17 November 2023

Tegan Cole
Senior Environmental Assessment Officer
Department of Planning and Environment

Mount Arthur Coal Mine (MP 09_0062) – Muswellbrook Shire Council comments on Modification 2 Modification Report

APPENDIX 8 FINAL LANDFORM PLAN

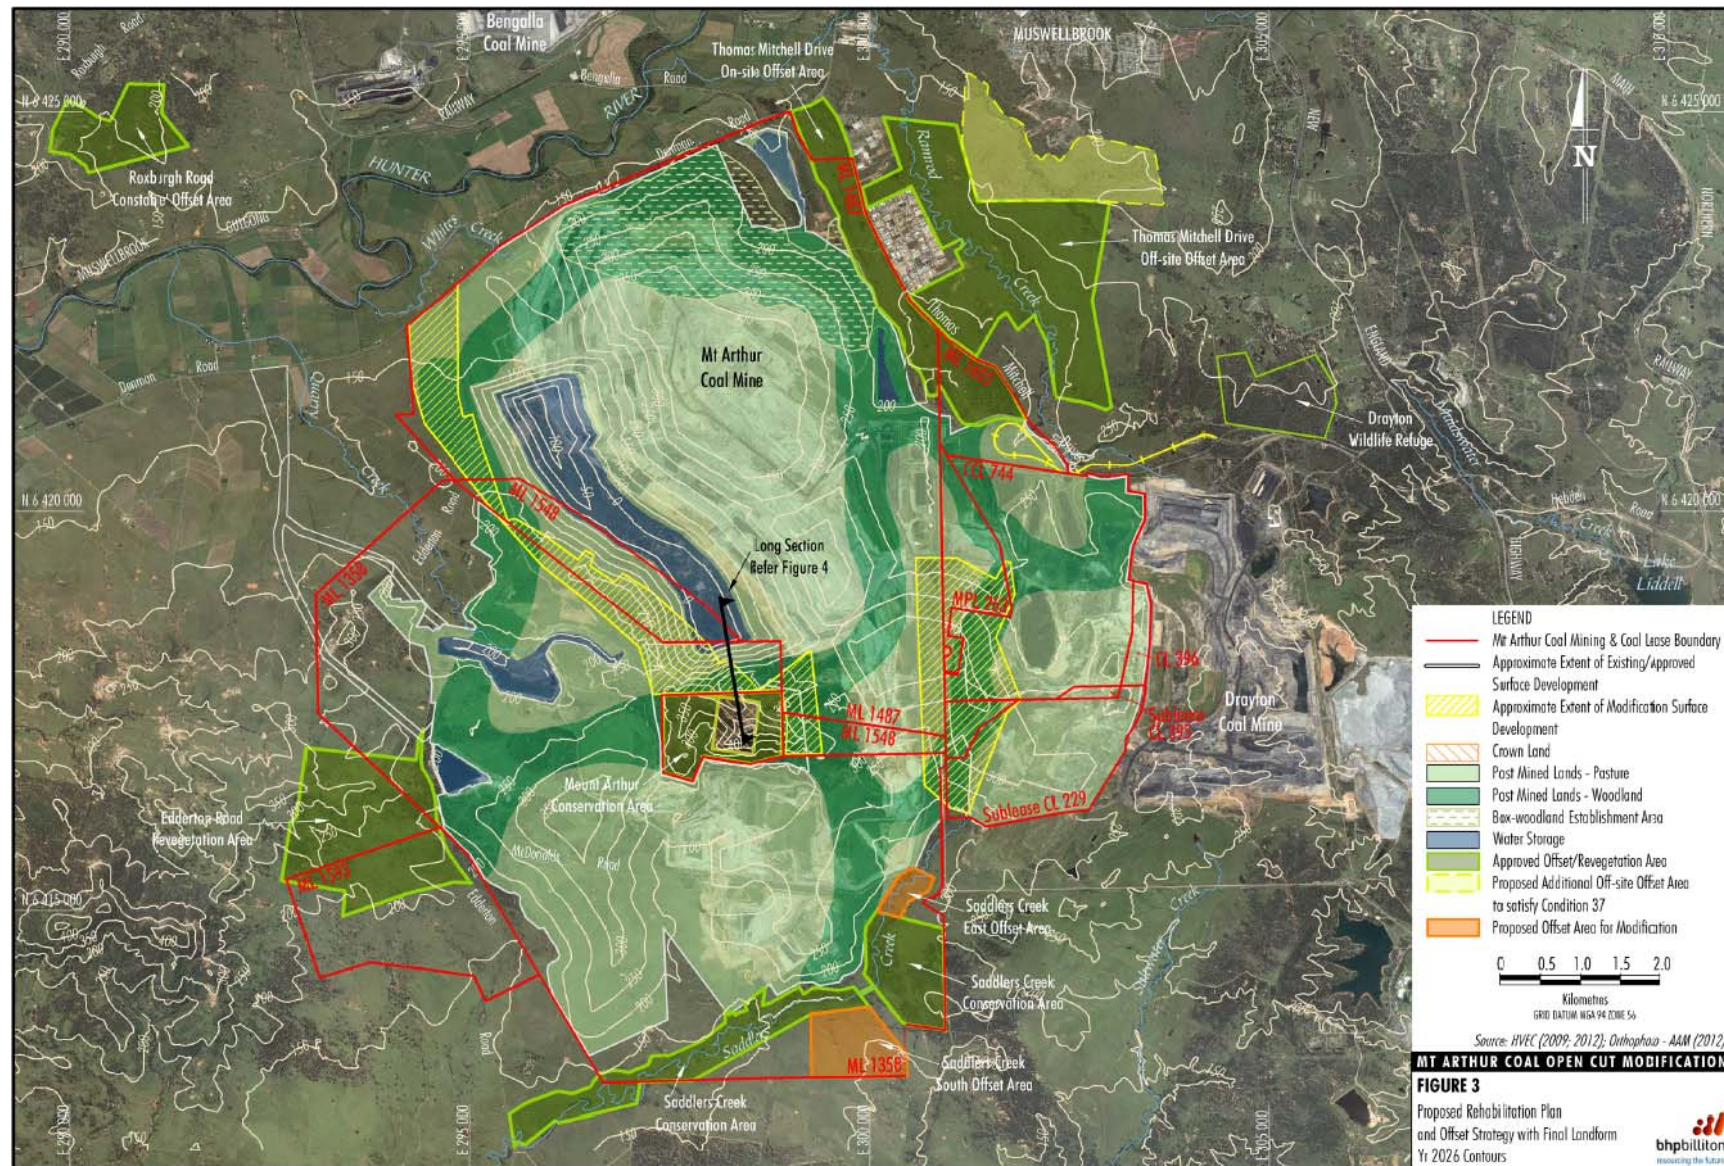
11. Council requests the following features be shown on the Final Landform figure:

- a. The location of the re-established Whites Creek;
- b. The location of outer faces of the waste rock emplacement areas with the proposed geomorphic design applied; and
- c. The location of the 33ha area proposed for Class II agricultural capability land.
